APPROVED
Limited building only review
Permit holder responsible for full compliance with the code

10/23/2023

HITE RESIDENCE

ANGIER, NC
919-369-7181

ROOF PLAN
SCALE: 1/4"=1'-0"

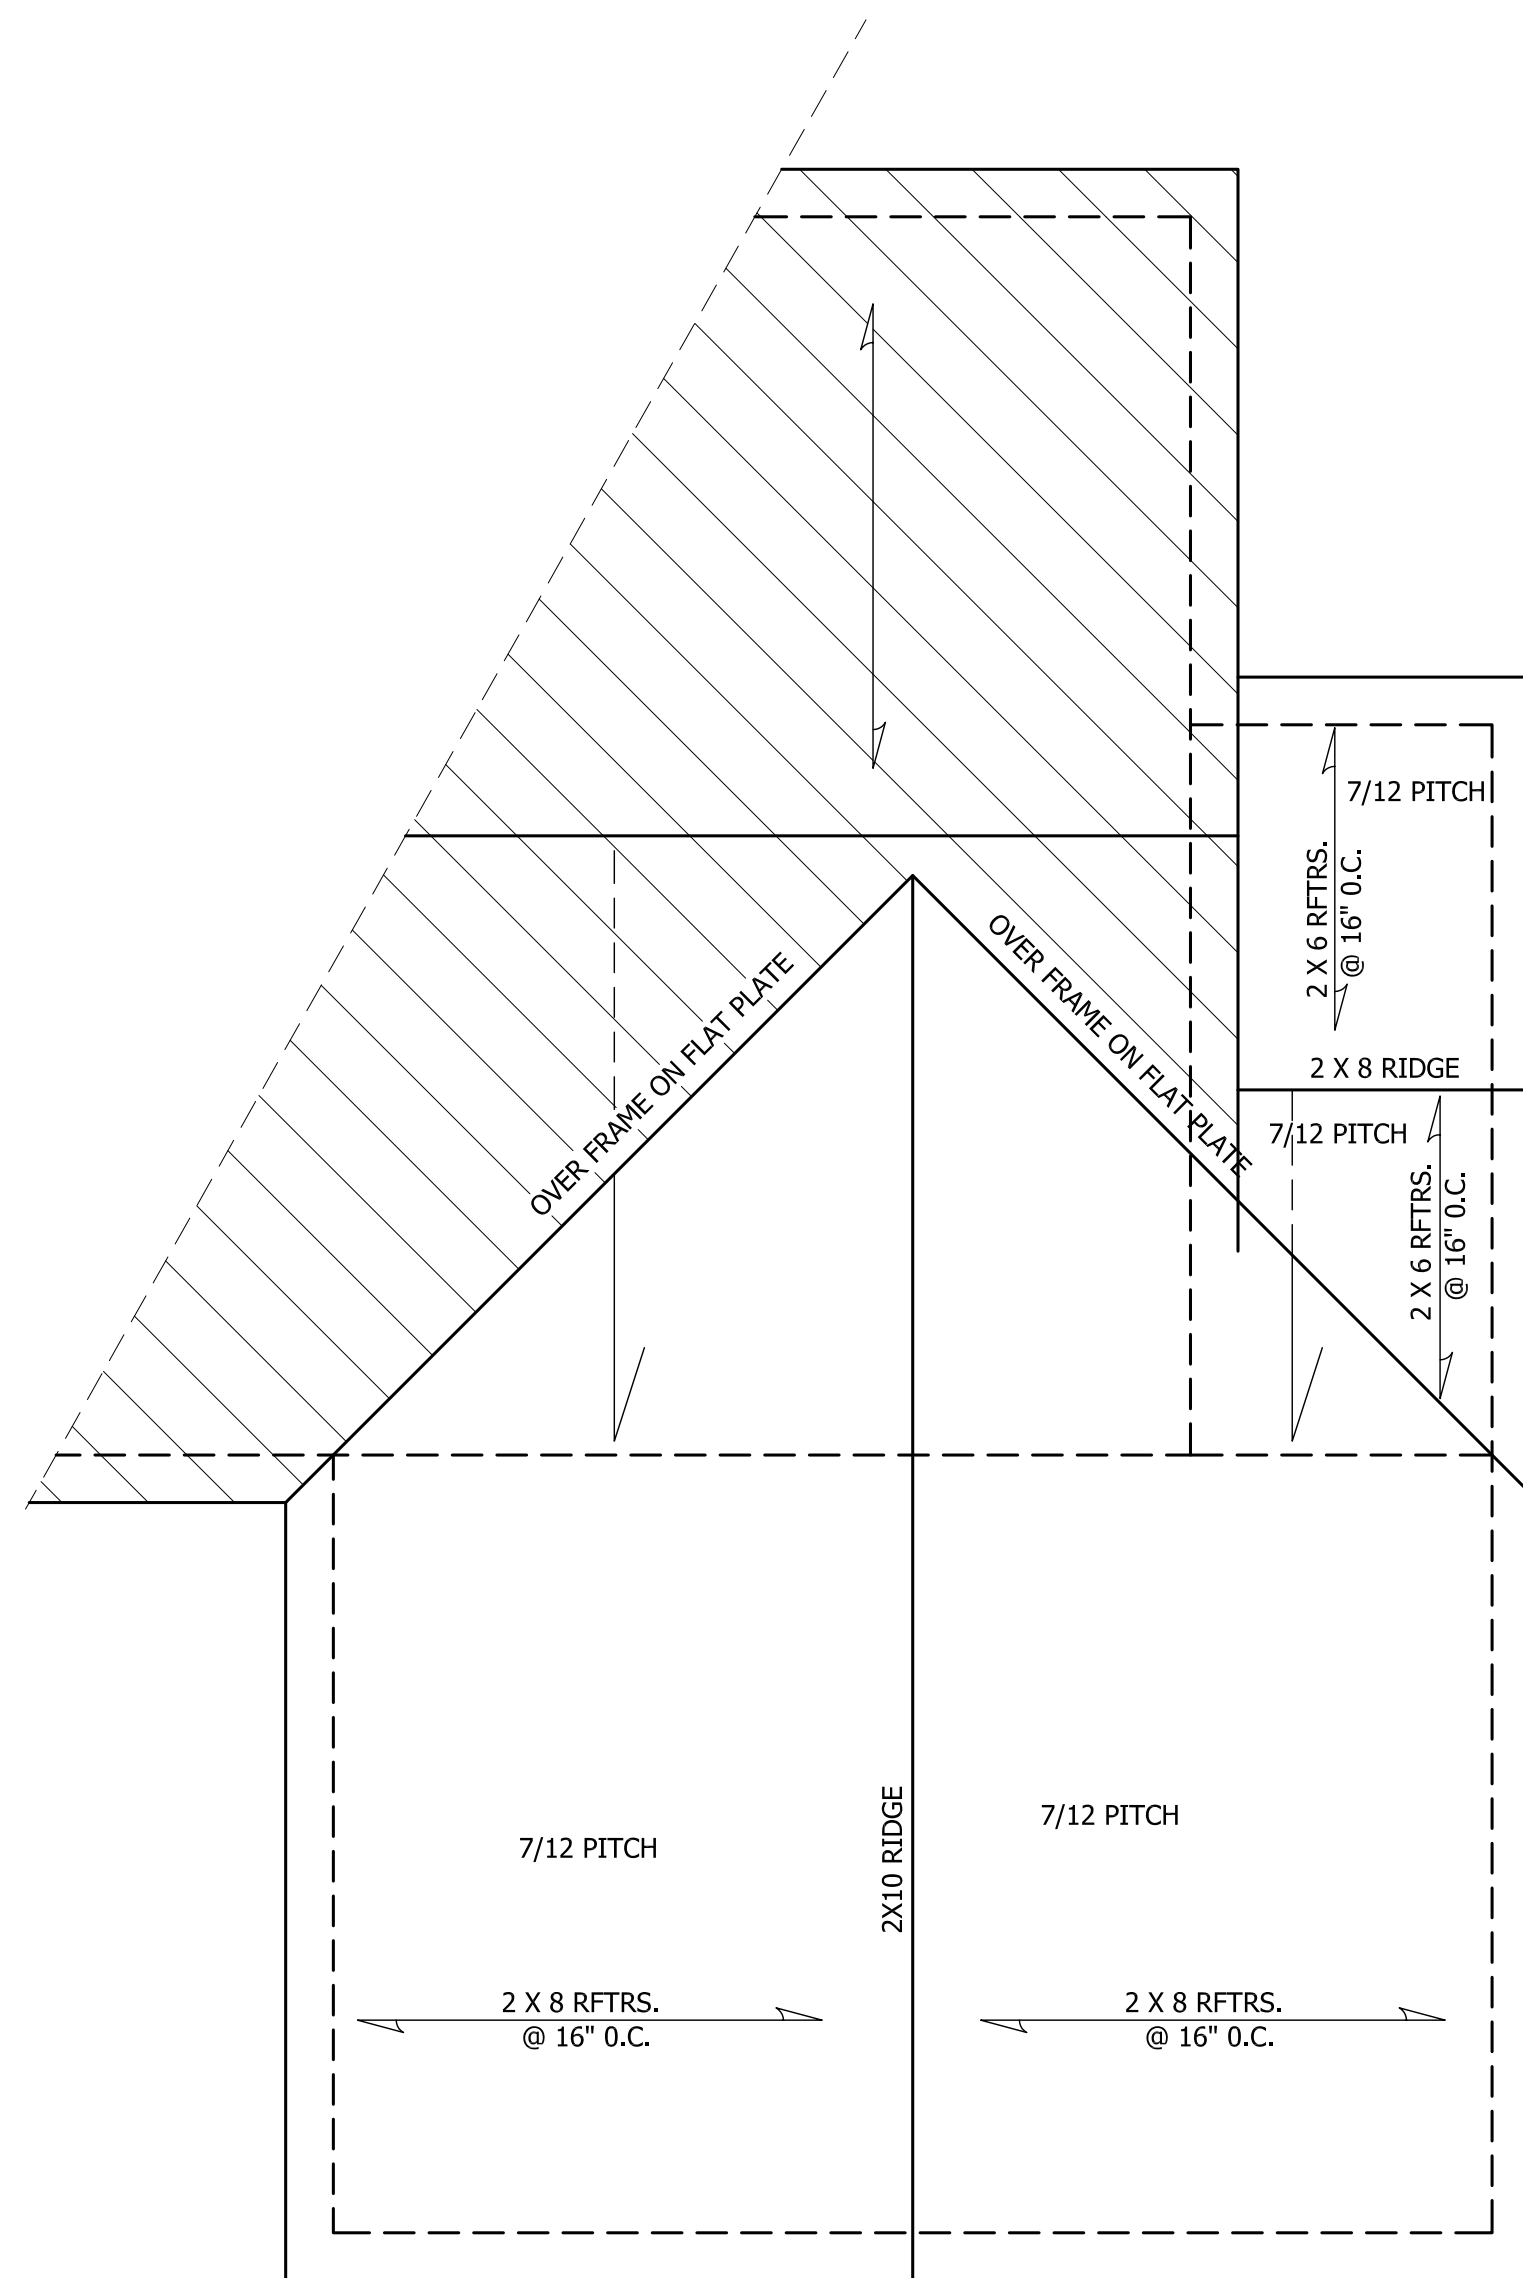
Building code requires ceiling joists in lower 1/3 of rafter span, as shown on page 3 wall detail. If this is to be built as a cathedral, the ridge must be designed as a beam that will carry roof load from the top.
